Re: Application 3/2025/0877 - Approval of details reserved by conditions 4 (Walling and roofing materials), 5 (Roof Lights), 6 (Windows and Doors) and 7 (Stone Flags) on planning permission 3/2025/0231. 3 Church Street Clitheroe BB7 2DD

These comments are on behalf of Clitheroe Civic Society.

**Window Details**  
1:5

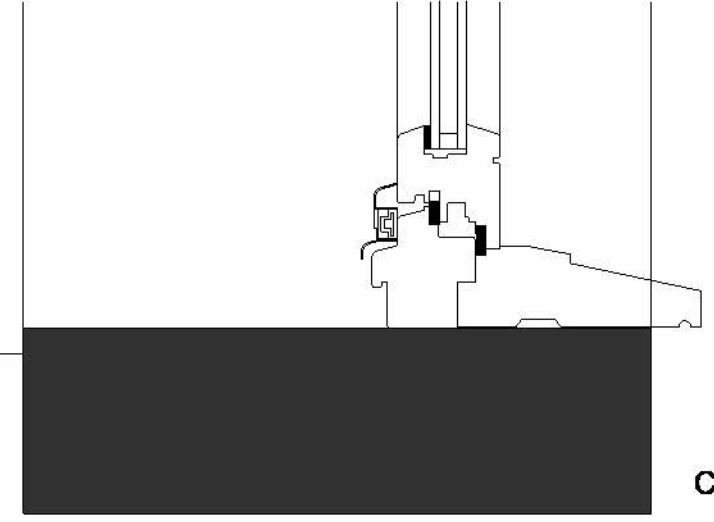
We have concerns regarding the proposed windows. We commented on an earlier application for this site that there was no survey of the existing windows, or discussion of their historical significance or condition. The application has therefore not justified why the existing windows cannot be repaired and retained. Clitheroe Conservation Area Management Guidance states: *'As a rule, windows in historic buildings should be repaired, or if beyond repair should be replaced 'like for like'. It is important that the design, scale and proportion of new windows should be sympathetic to the character of the building.'* The proposed windows are a mock sash design, which is not a like for like replacement. The frames are too chunky and out of proportion with the building and with the other buildings on the street. They are not appropriate for use on a listed building or within Clitheroe Conservation Area, and would cause harm to the significance of both the grade II listed building and the designated Conservation Area. We recommend that the applicant undertakes a window condition survey and frames should be retained and repaired wherever possible, with thermal upgrades such as secondary glazing added. Where frames are beyond repair, then full sliding timber sash windows of the same proportions as the existing should be used. Guidance on windows in historic buildings can be found here: <https://historicengland.org.uk/images-books/publications/traditional-windows-care-repair-upgrading/heag039-traditional-windows-revfeb17/>
